From: Michael Eastham
Sent: 17 December 2020 14:16
To: Planning Scanning
Subject: FW: A/166/20/DOC - Manor Nursery, High Street, Angmering

Please scan and upload the email below from the applicant confirming that we have an extension of time (EoT) to determine discharge of condition application **A/166/20/DOC** to Tuesday **12th January 2021**.

From: Laura Gibbons [REDACTED]
Sent: 16 November 2020 11:07
To: Michael Eastham <Michael.Eastham@arun.gov.uk>
Cc: Paul Cann <Paul.Cann@arun.gov.uk>
Subject: Re: A/166/20/DOC - Manor Nursery, High Street, Angmering

CLIENT	Roffey Homes Ltd		
PROJECT	Manor Nurseries Site Angmering		
TITLE	Proposed Drainage Strategy		
DRAWN	DATE	PROJECT NO.	
T Zajac	Mar 2018	22995	
ENGINEER	CHECKED	DWG. NO.	REV.
S Magowan		102	D
SCALE	1:250 @ A1

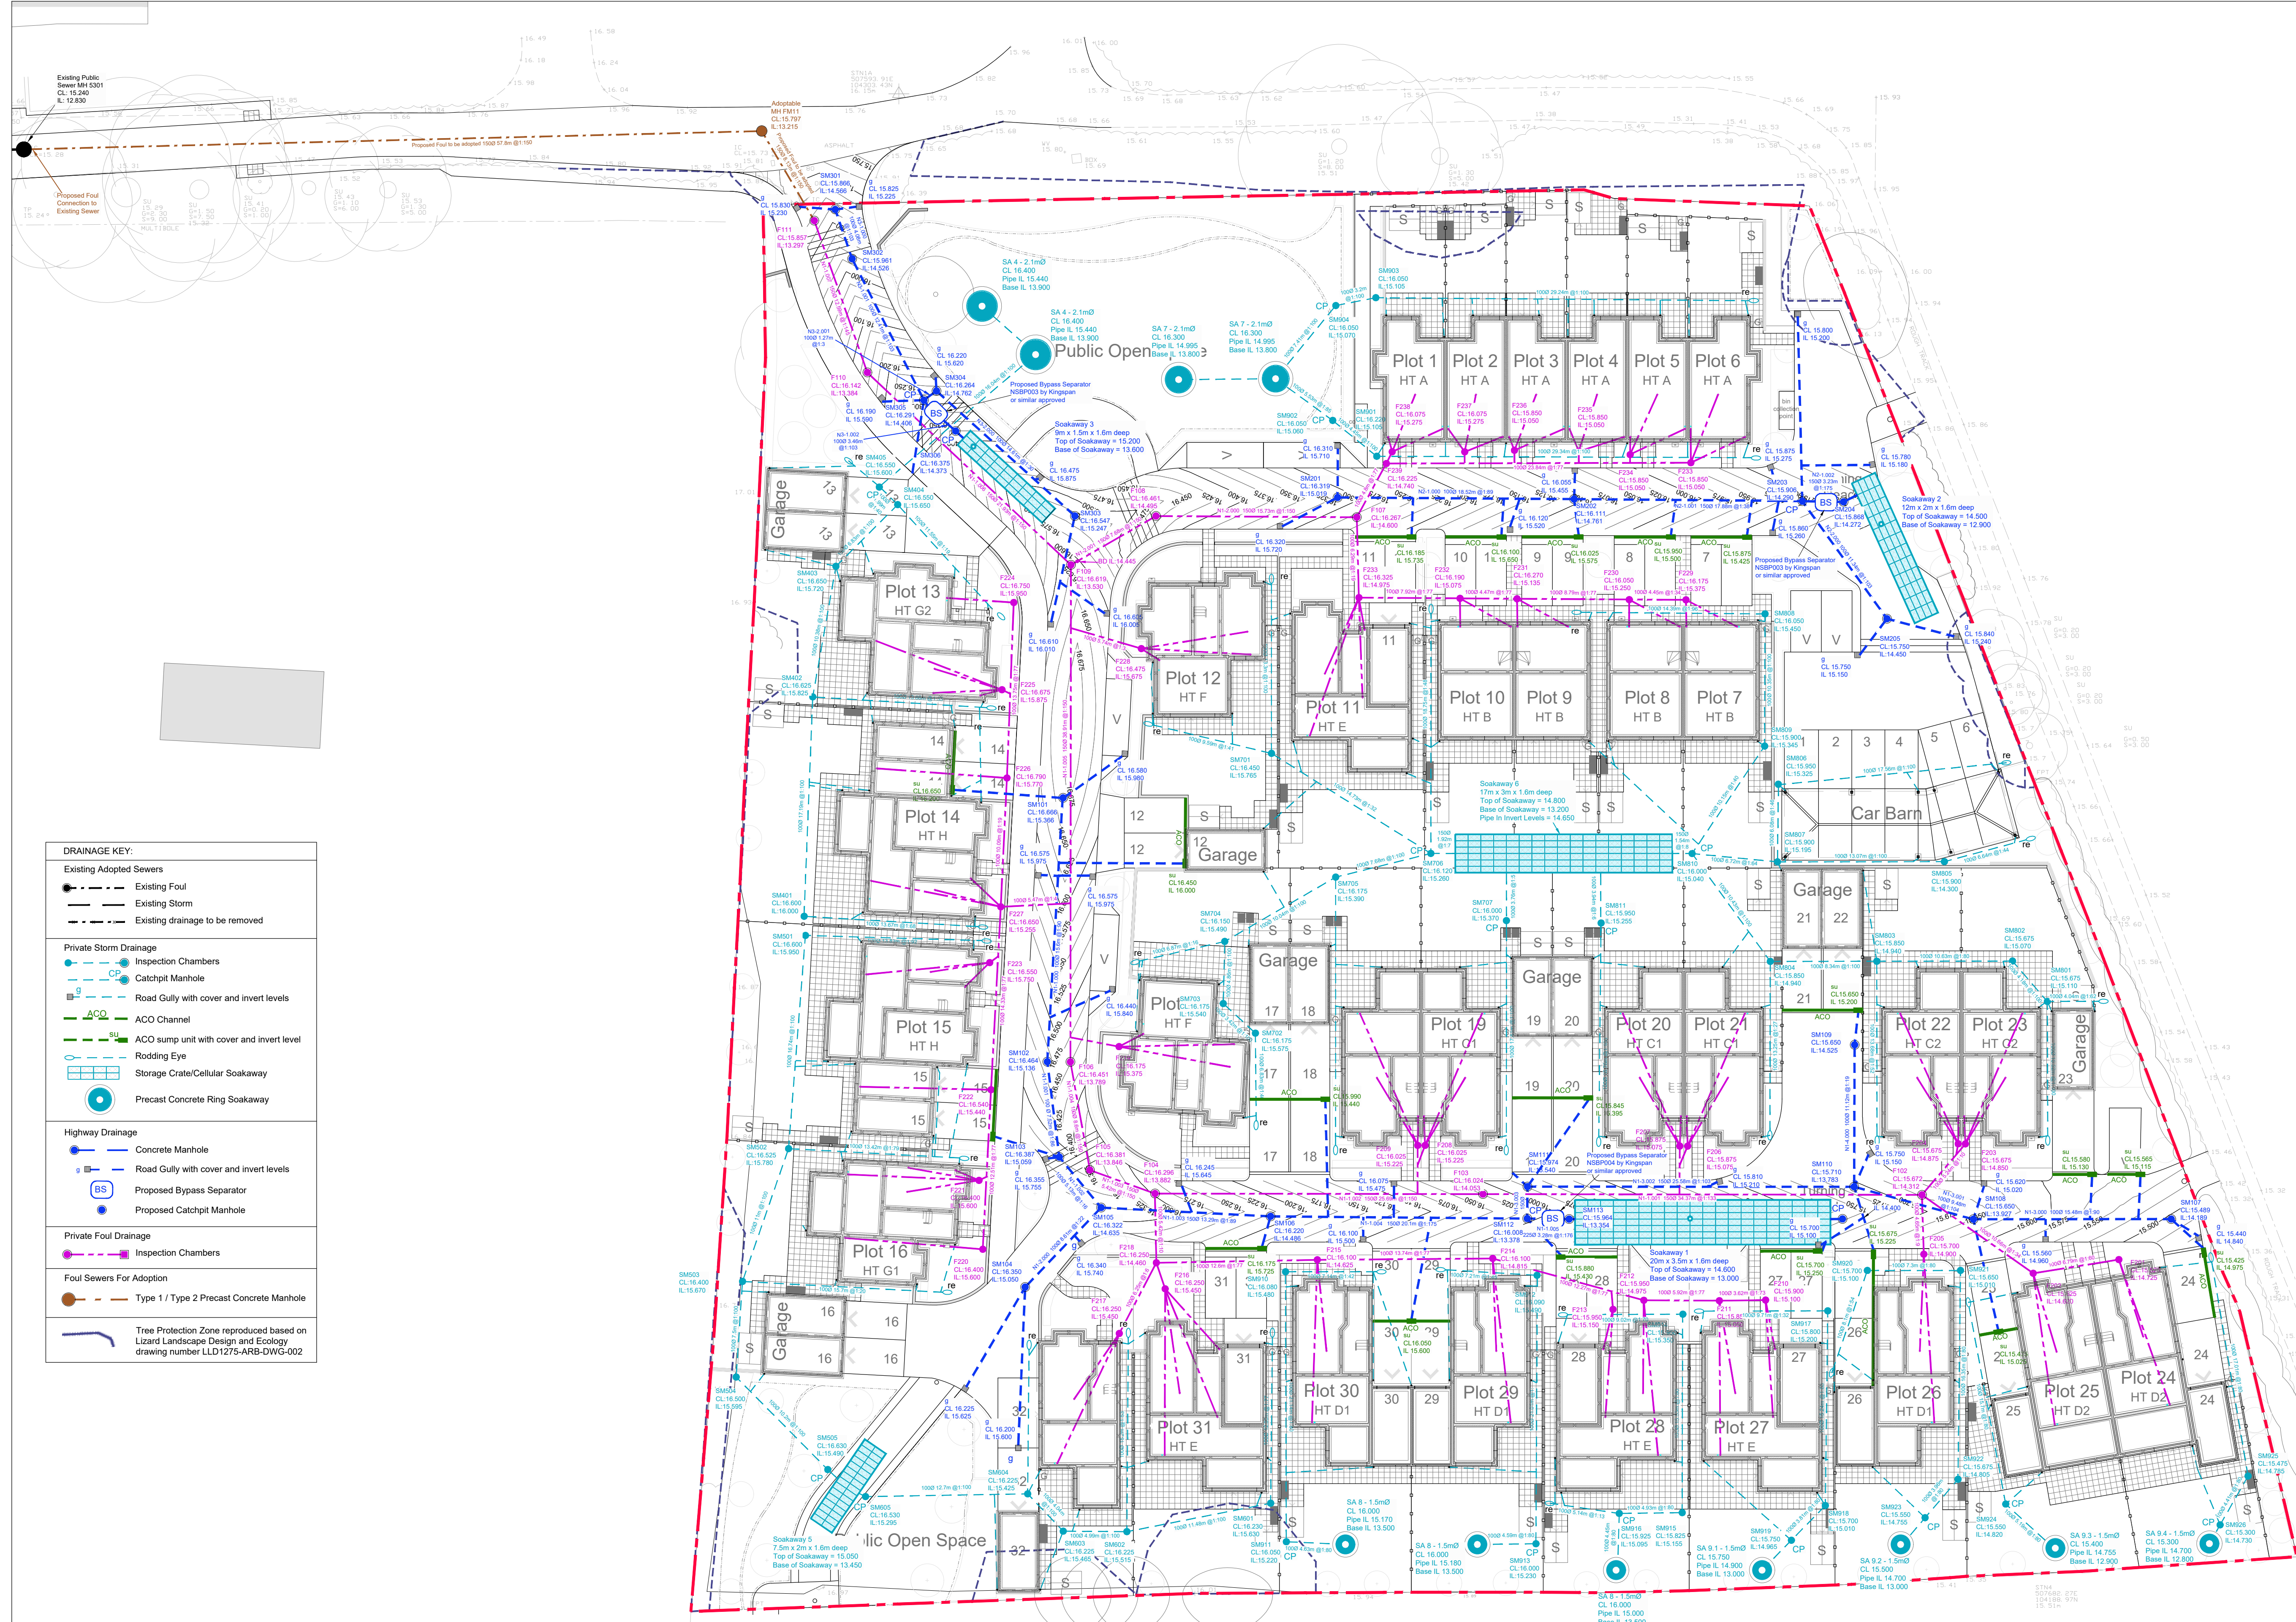
2. Please detail invert and cover levels of gullies and ACO drains. 102_E Drainage has now been updated to include the requested details.
3. Some pipes appear to terminate without connections. For example where are the pipes upstream of N1 2.000 connecting to/from? This was a technical error with the drawing layers and has now been rectified.

5. It is unclear how the pipes that are supposed to be able to pass above soakaway 1 will in reality do this. They are draining surface features, i.e. ACO and gullies, and are meant to pass above the top of the crate which is at 14.6mAOD and then within 1m connect into a pipe that has an upstream invert level of 13.943. Please detail how this is supposed to work especially given some of these connections are not via manholes. The

6. **All pipes must achieve 1m/s velocity at full bore.** The surface water system will remain private and is not being offered for adoption. Sewers for Adoption requires a velocity of 1 m/s, however for a private system BSEN 752 and Building Regulations Part H apply and require a minimum velocity of 0.75 m/s. The velocity of the system will determine the depths of the pipework, as a higher velocity will increase a lot of the gradients, this will increase the depth of the system and subsequently increase the depth of excavation during construction needlessly. The system has been designed using a minimum velocity of 0.75 m/s which is acceptable based on policy and relevant regulations.

7. SA4 has a maximum water level of 16.575, this is greater than the cover level stated on the drawings. The calculation details for SA 4 are different to those on plan. Please correct so that they are consistent. Cover level updated with calculations.

8. The calculation details for SA 7, SA8, and SA9 are different to those on plan. Please correct so that they are consistent. Calculations updated.
9. Construction detail drawings need to be provided, as per our checklist. Please see 502__Construction Details.

network has been slightly rearranged now in this area and also more details have been included to make it clear how this area works. This has all been checked and there will be no issues with the performance of the network or constructing what is proposed.

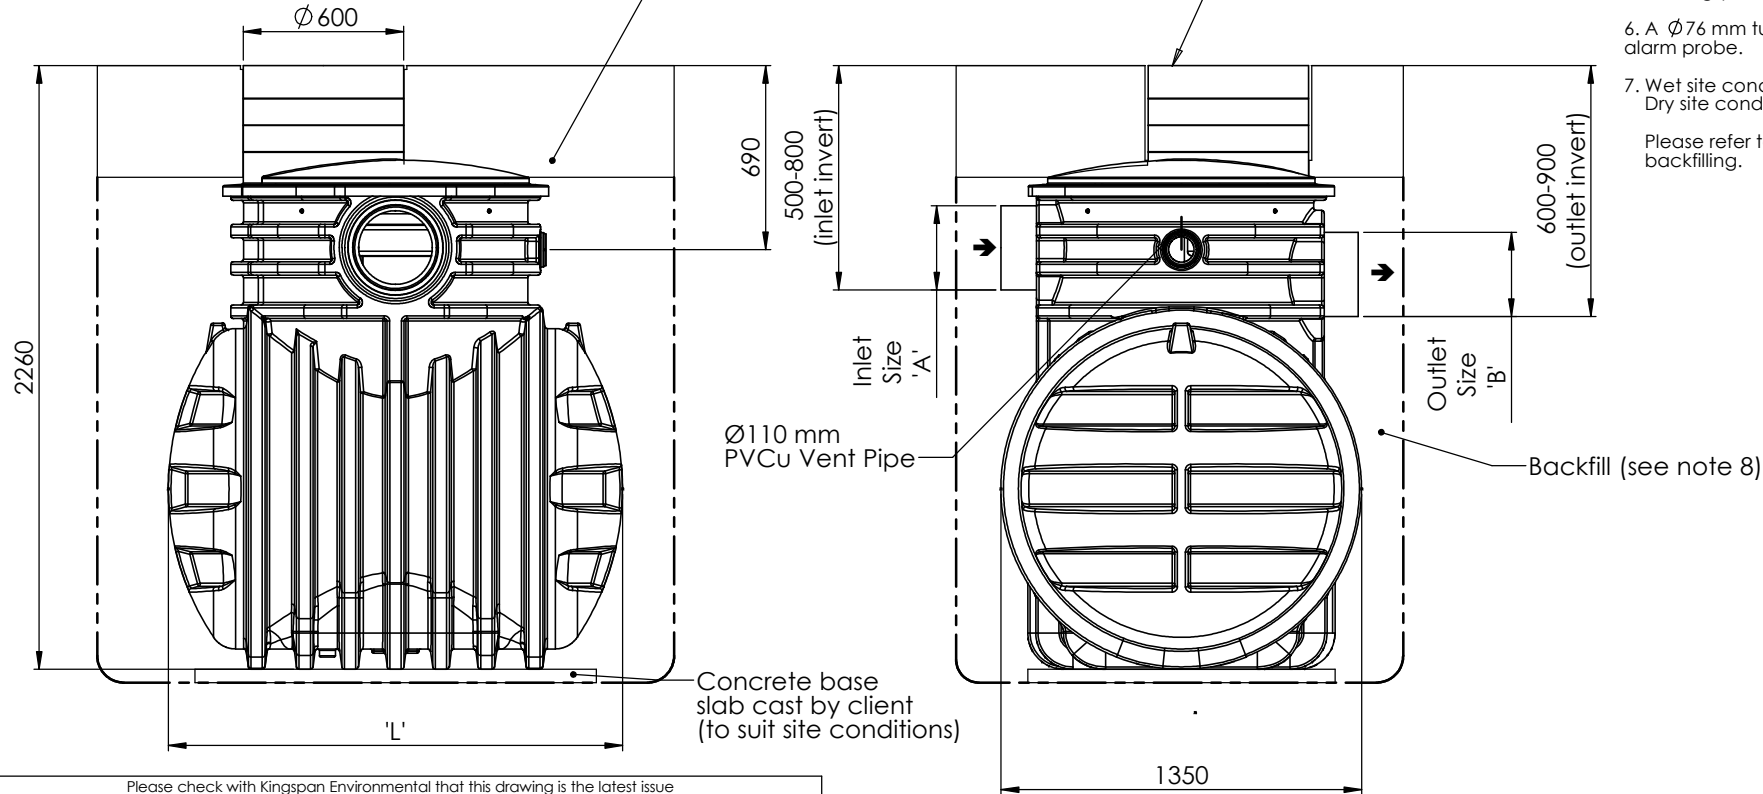
1. (Relating to previous comment no. 4) Please provide evidence that the bypass separators are of a sufficient size that they will treat the 1 in 1 year plus 40% climate change event flow. I.e. please supply calculation results for the networks with separators on for the 1 in 1 year plus 40% cc event to demonstrate what flow is occurring through the network in this event.

2. (Relating to previous comment no. 4) The documents provided did not specifically detail the hazard mitigation indices being achieved for total suspended solids, metals, and hydrocarbons. Please detail. Bypass separators are known to not be effective at removing soluble pollutants, how are these being removed?

4. Please provide details of the proposed bypass separators and how these will meet the requirements for hazard mitigation indices. Please see attached data sheets and Declaration of Performance.
